MEMORANDUM

RE: Vanderwall Residence Remodel, City of Mercer Island Permit Number: 2101-202

This memo summarizes my responses to the various structural items shown on the City of Mercer Island Corrections Notice dated May 6, 2021.

Drawing Title
FOUNDATION PLAN

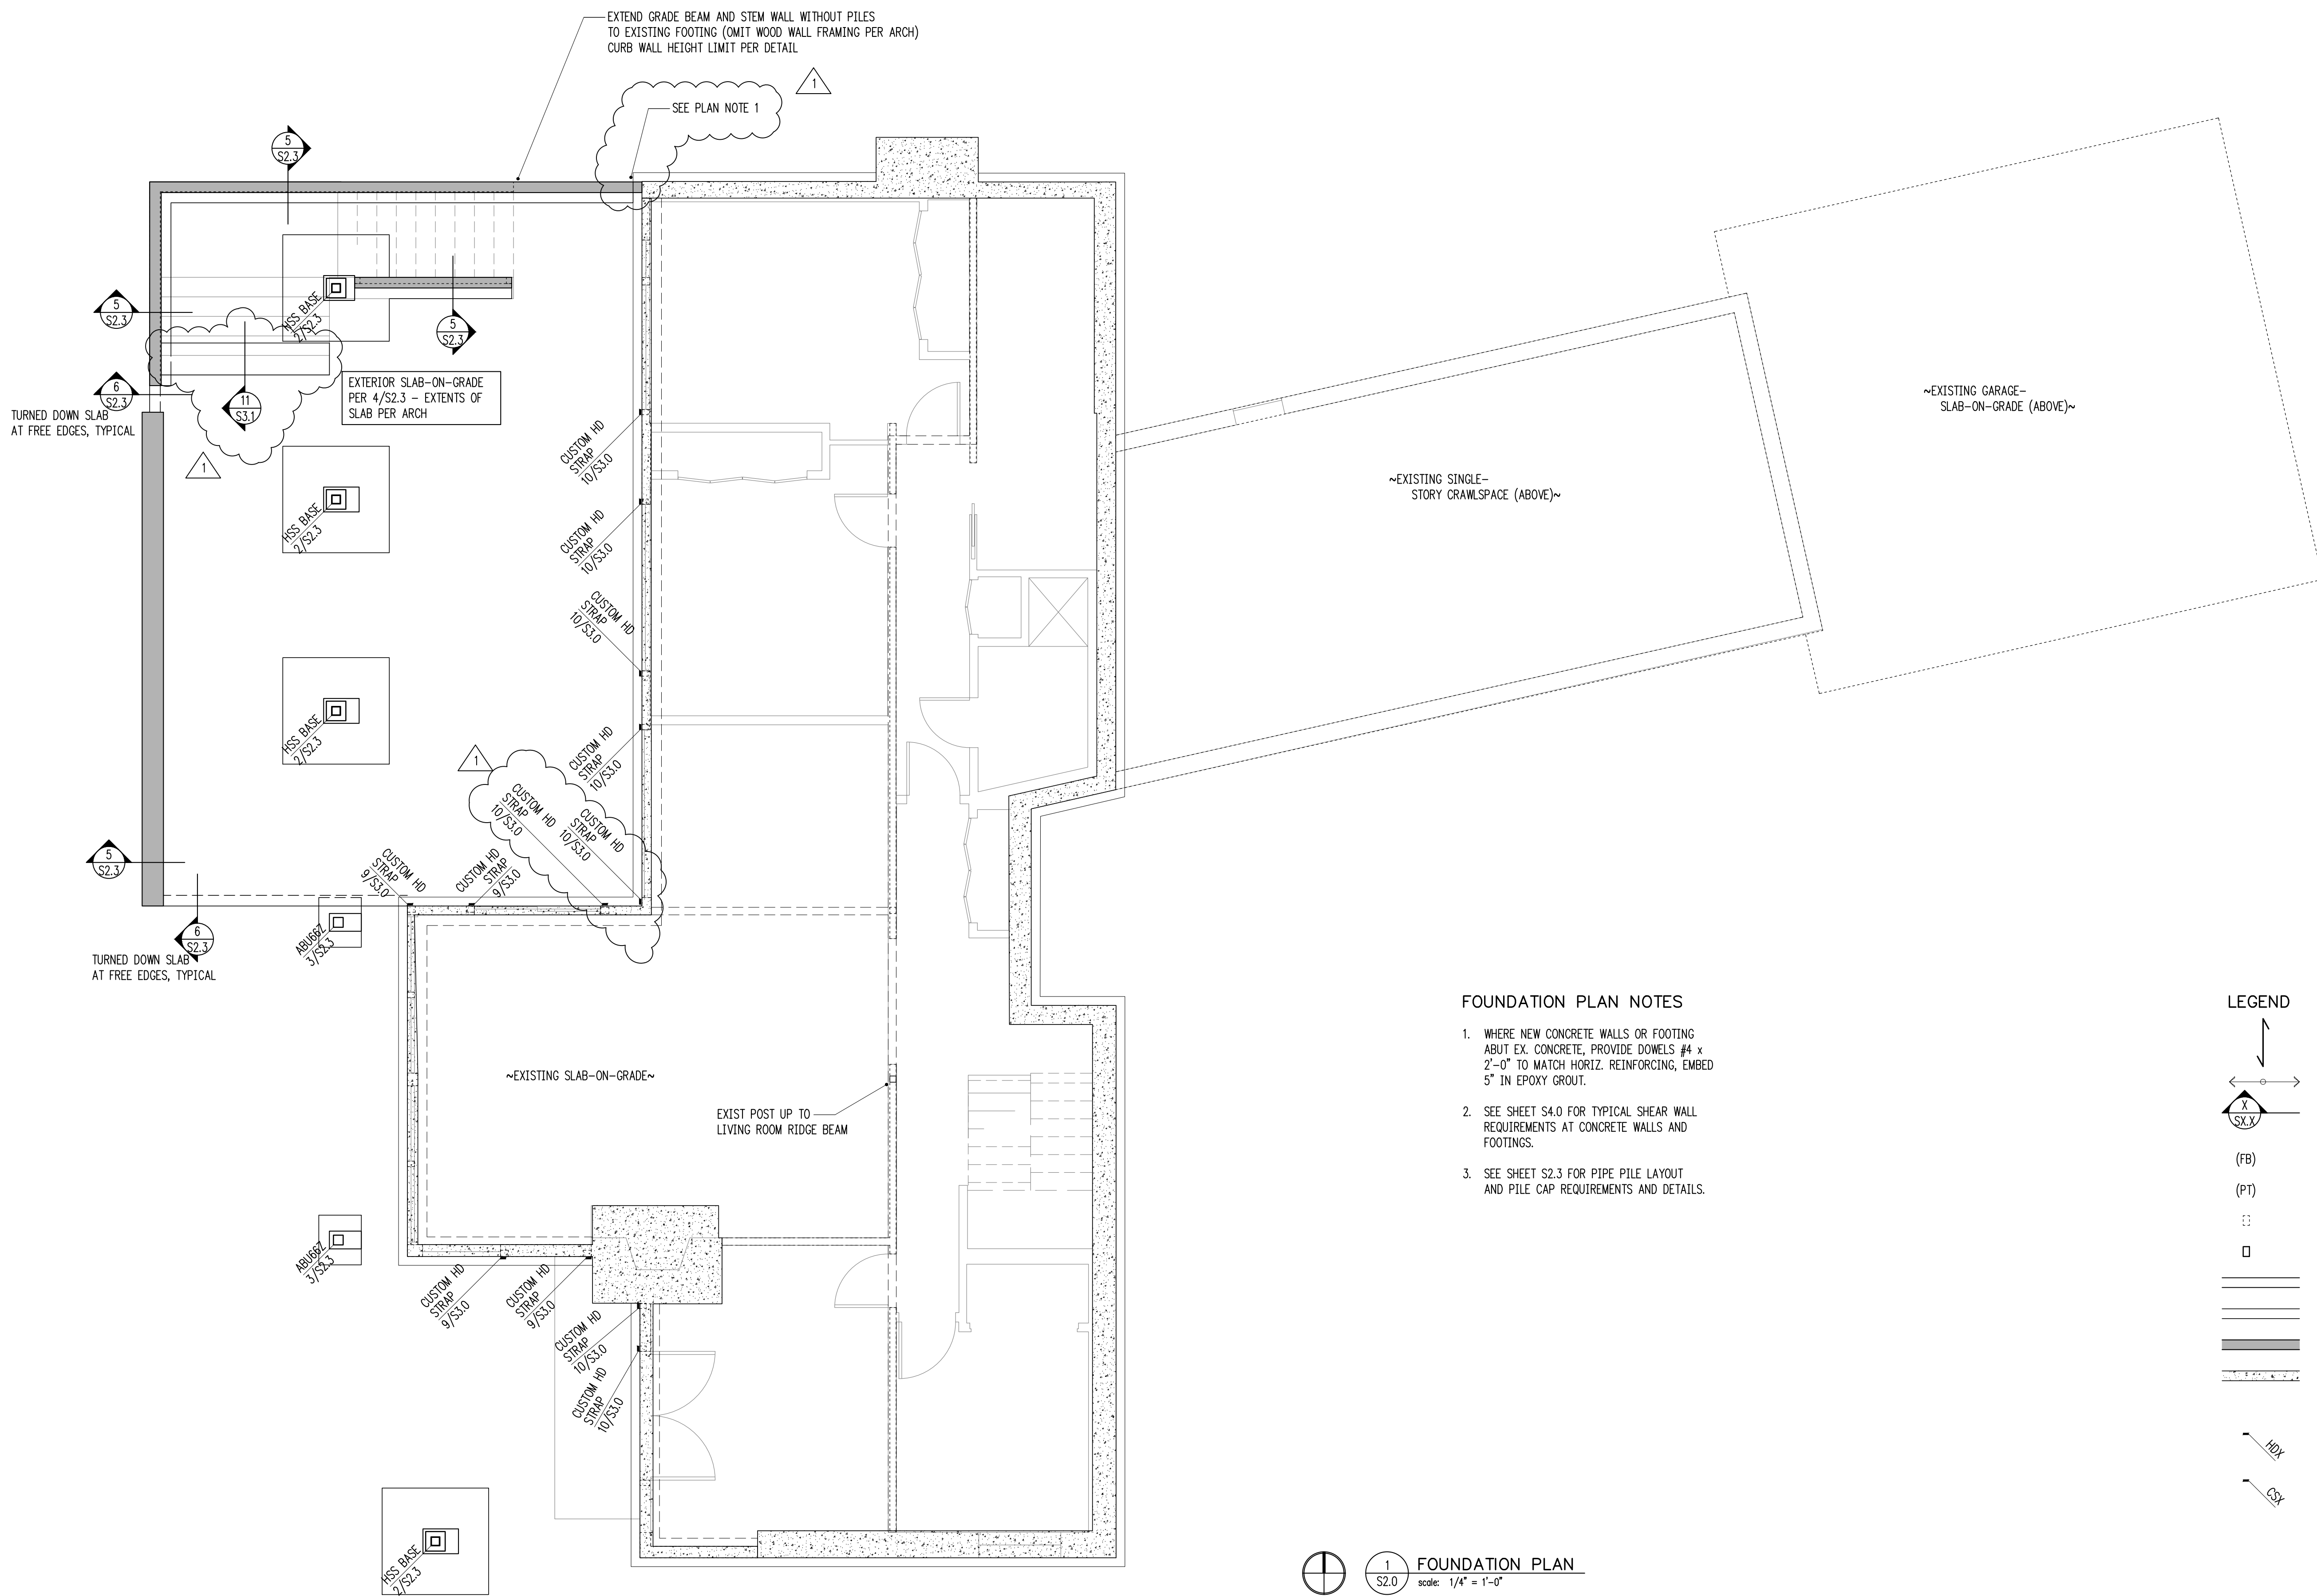
S2.0	1) <i>Please indicate how the now foundation wall and grade beam are attached to the existing structure.</i>
-------------	--

S2.0	2) <i>Do these holdowns include the reactions from the holdown transfer beams above? Where holdowns don't align with holdowns above (i.e. at ends of holdown transfer beams), detail and provide supporting calculations as necessary to resolve additional holdown load into adjacent holdowns. Alternatively, provide continuity for holdowns to foundation.</i>
-------------	--

Foundation Note 1 outlines doweling requirements. Plan callout has been added for clarification.

See **Attachment A** calculations for verification of holdown strap capacity including dead load resistance.

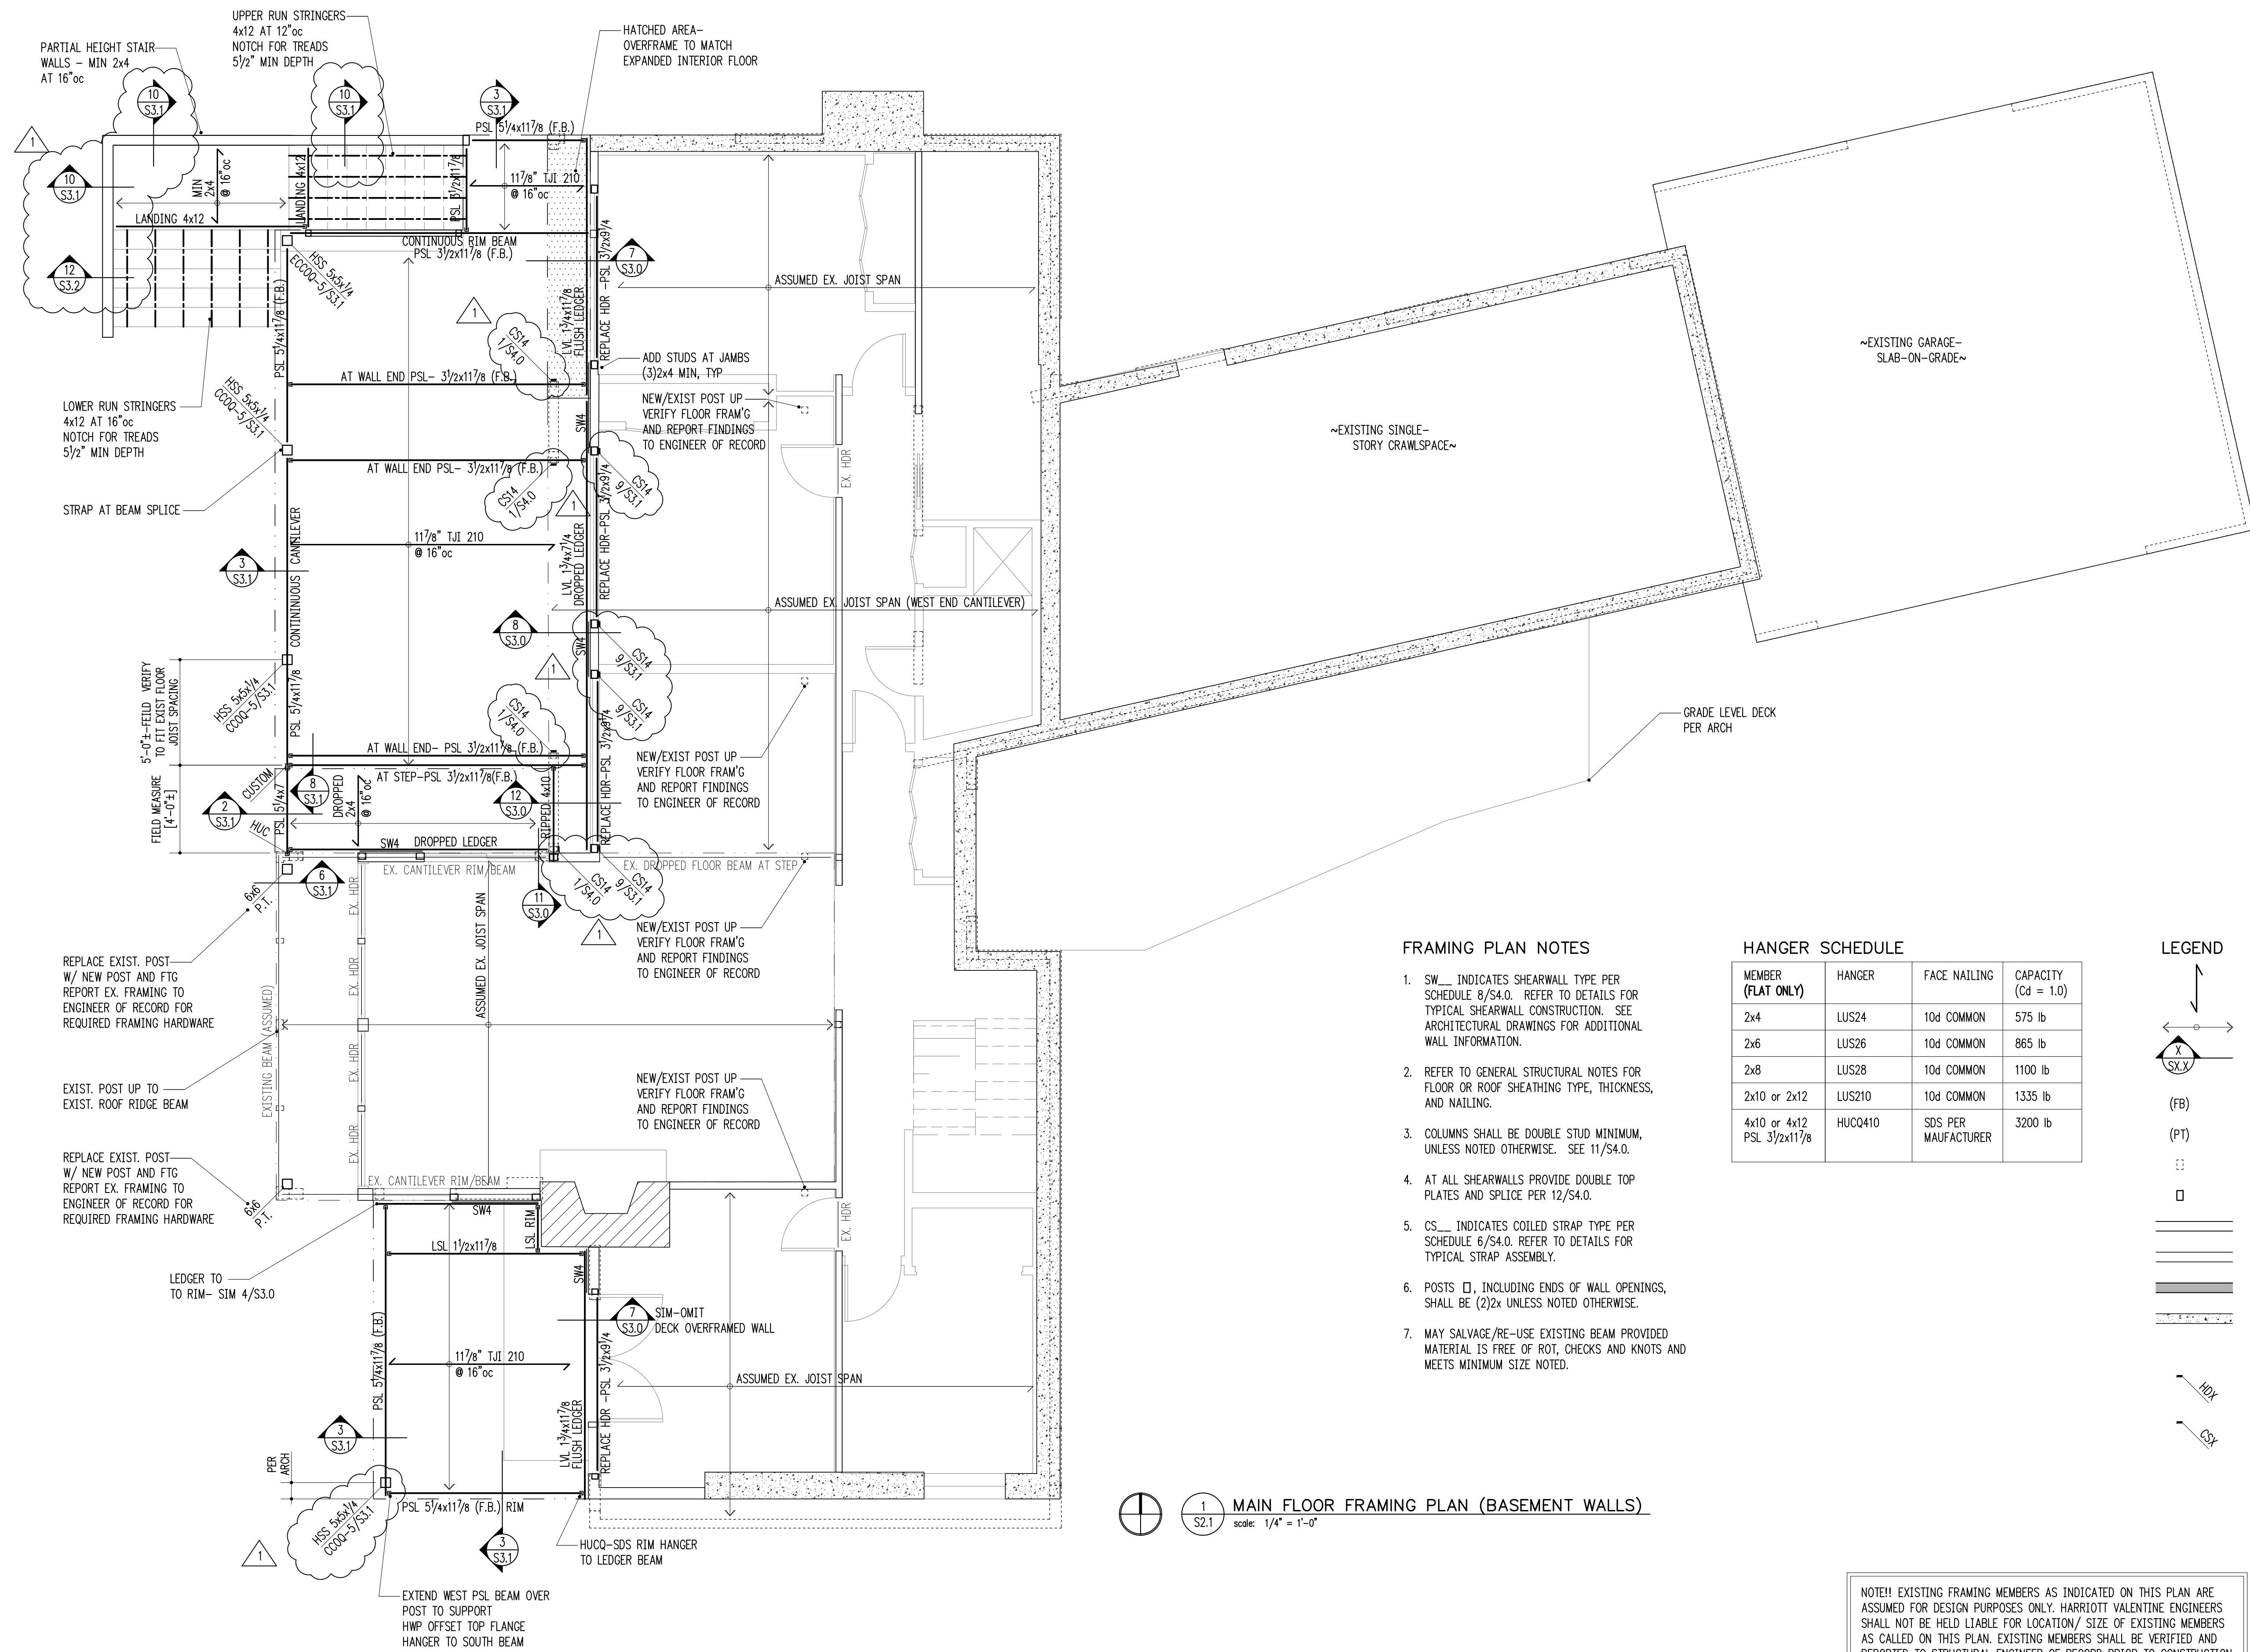
S2.1	1) <i>Provide support for stringers at base of stairs.</i>
-------------	--

S2.1	2) <i>Please provide detail through partial height wall. Are studs continuous? Are the braced to the stair diaphragm?</i>
-------------	---

- S2.1** 3) *Provide complete load path to foundation as necessary to fully resolve uplift reactions at the ends of all holdown transfer beams.*

- S2.1** 4) *Provide complete load path to foundation as necessary to fully resolve uplift reactions at the ends of all holdown transfer beams. Provide hanger capable of resolving uplift force.*

- S2.1** 5) *Please include existing roof wind load in the lateral design or demonstrate additional load is not critical.*

- S2.1** 6) *Indicate how interconnectedness between portions of the structure (deck and house) is to be provided.*

- S2.1** 7) *Provide lateral connection at deck as required by IRC Section R507.2.4 and as required to resolve rotational forces.*

Detail has been added to show connection to slab at base of stairs.

Detail has been added to show wall bracing at stairs and landing

Straps and related details have been added to S2.1 to communicate uplift reactions to jambs at the lower level. Additionally, another foundation strap has been added to S2.0 at the south end.

See **Attachment B** calculations for verification of holdown strap capacity including dead load resistance.

Wind loads to the roof were included on Page 52 of the calculations and are demonstrated to be less than or approximately equal to seismic loads. Due to the weight of the deck pavers, the lower level was purely seismic controlled.

Details 7, 8 and 12 on S3.0 show various conditions where the deck and house structure interface.

Post in southwest corner was changed to a steel HSS cantilevered column. This provides an additional resisting line.
